Recommendation: Approve

Applicant: Dave & Amy Brace

Proposal: Discharge of Conditions 3 (doors, windows and louvres), 4 (stone sample panel) and 5 (roof material sample) of 20/00672/F

W
01

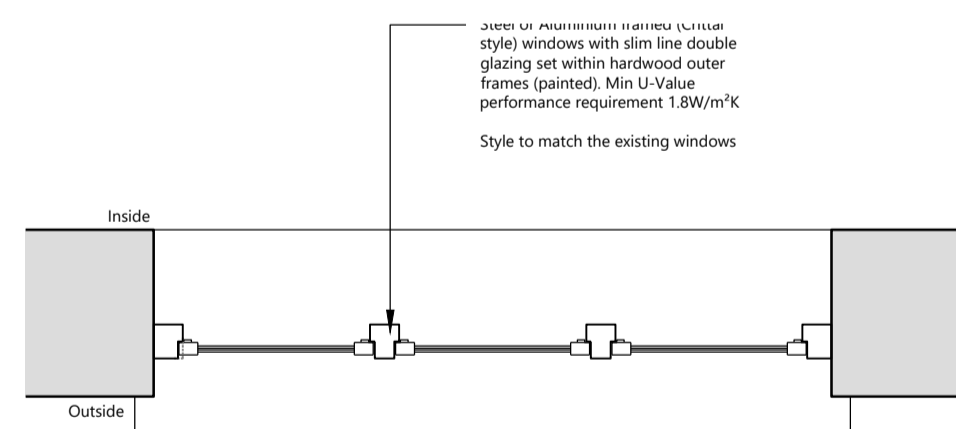
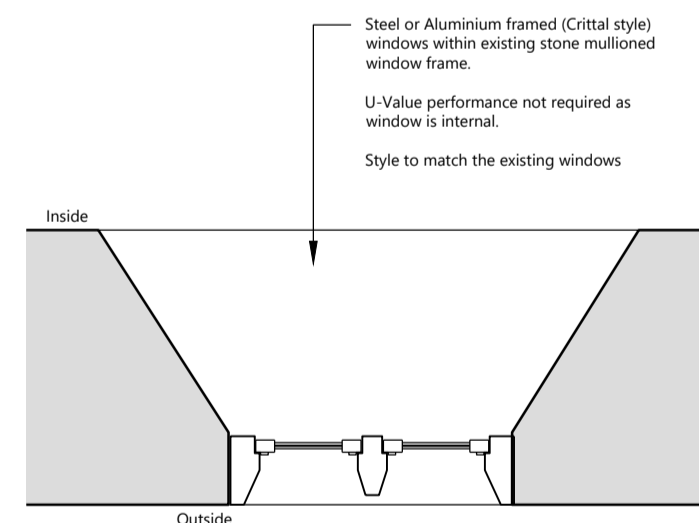
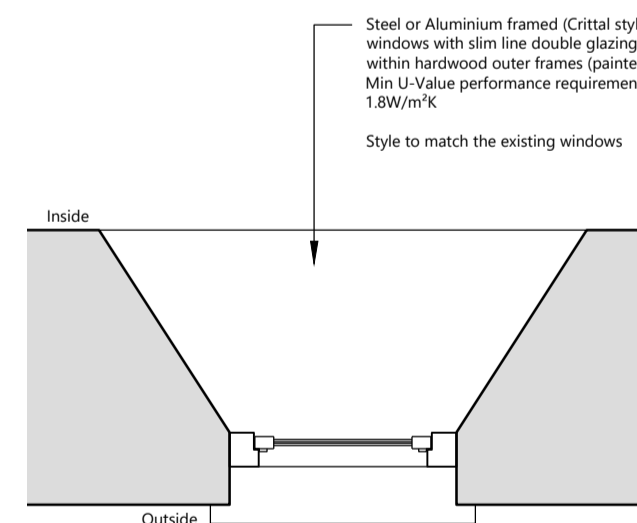
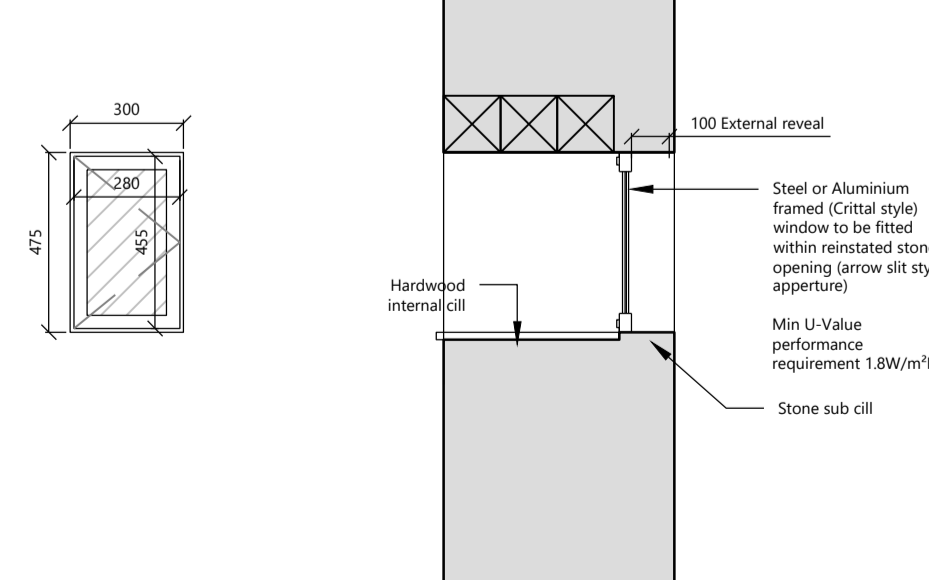
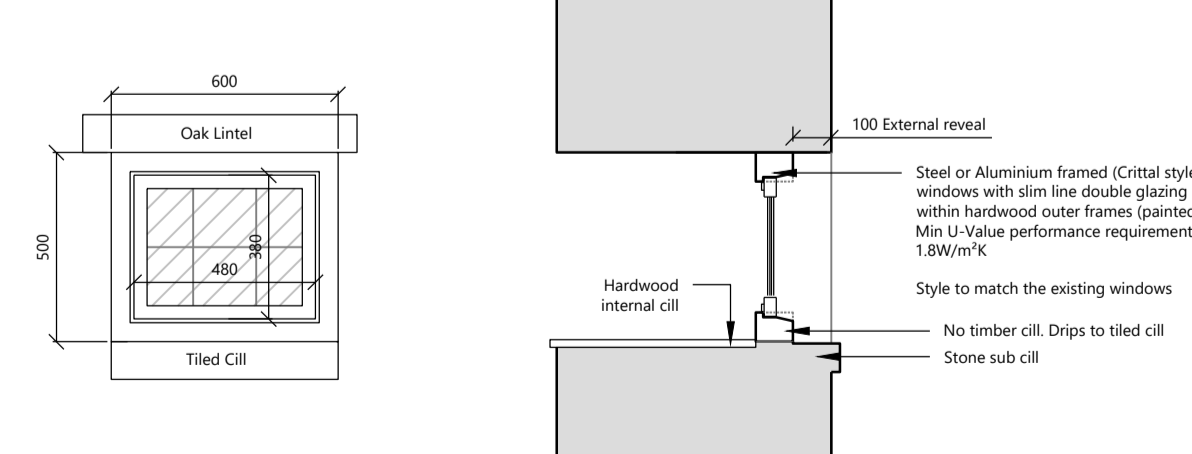
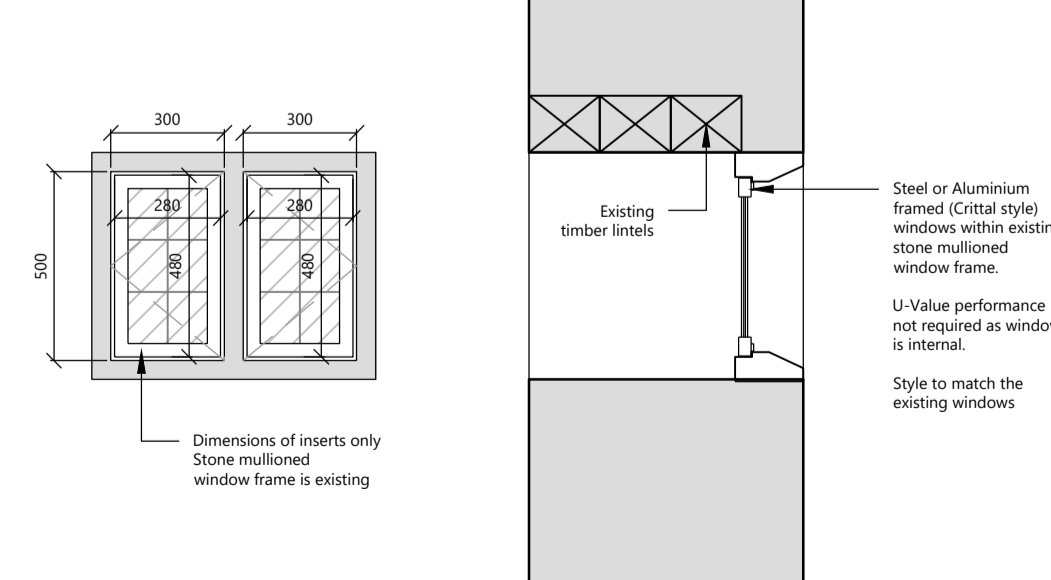
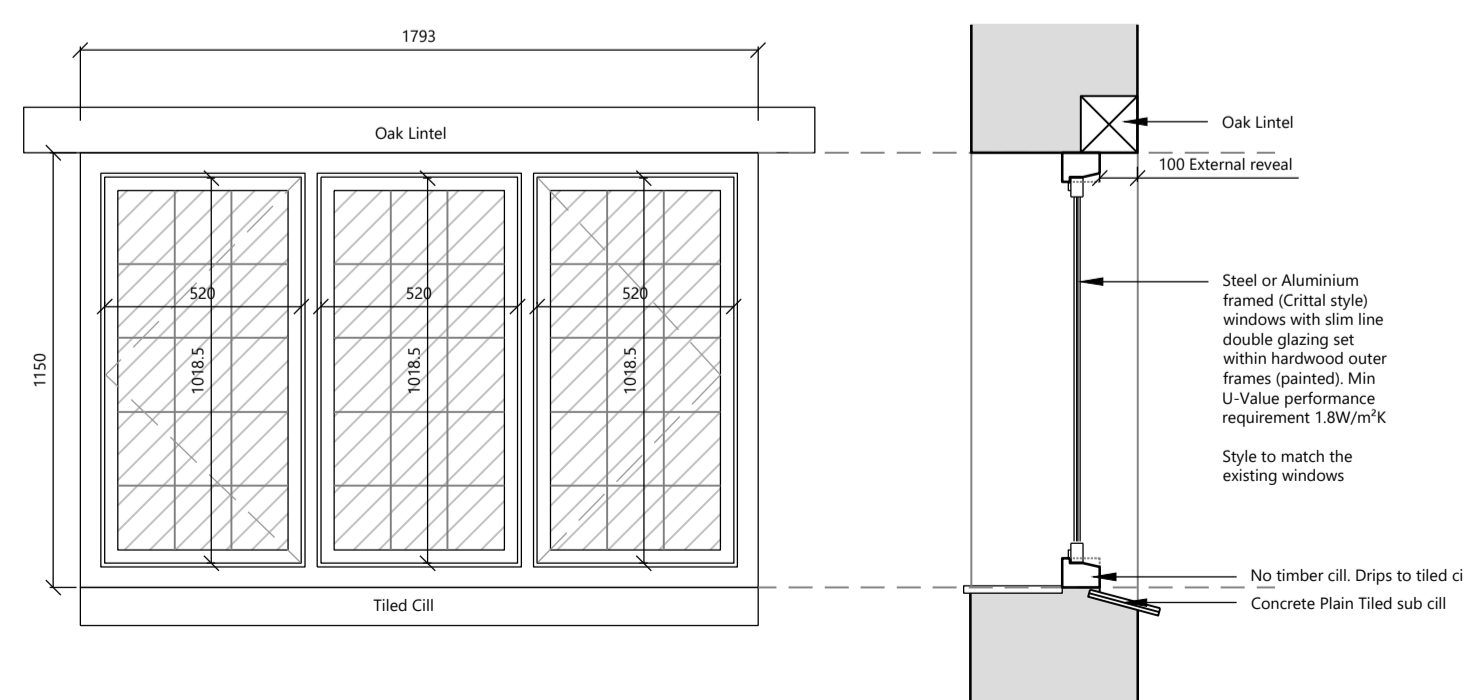
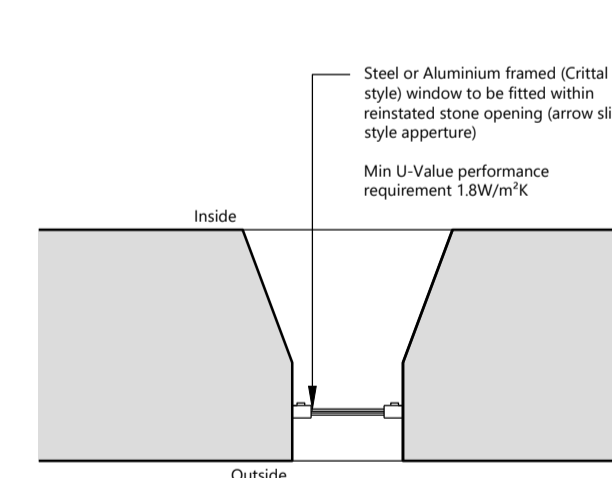
Raised various questions regarding the windows. There are not enough details to discharge the joinery details condition, and the details of the door proposed are not correct – Objection

The Conservation Officer raised concerns that the details for the high window in the existing gable end above the extension were not the same size as the approved drawing. The agent has explained that the original approved drawing showed a approximate size as it wasn't until they had scaffolding up that they knew what size it is. It is still intended to fit the window into the existing window surround. Joinery details for the window have now been submitted with the agent's comments. This window is now acceptable.

The joinery details are now considered acceptable.
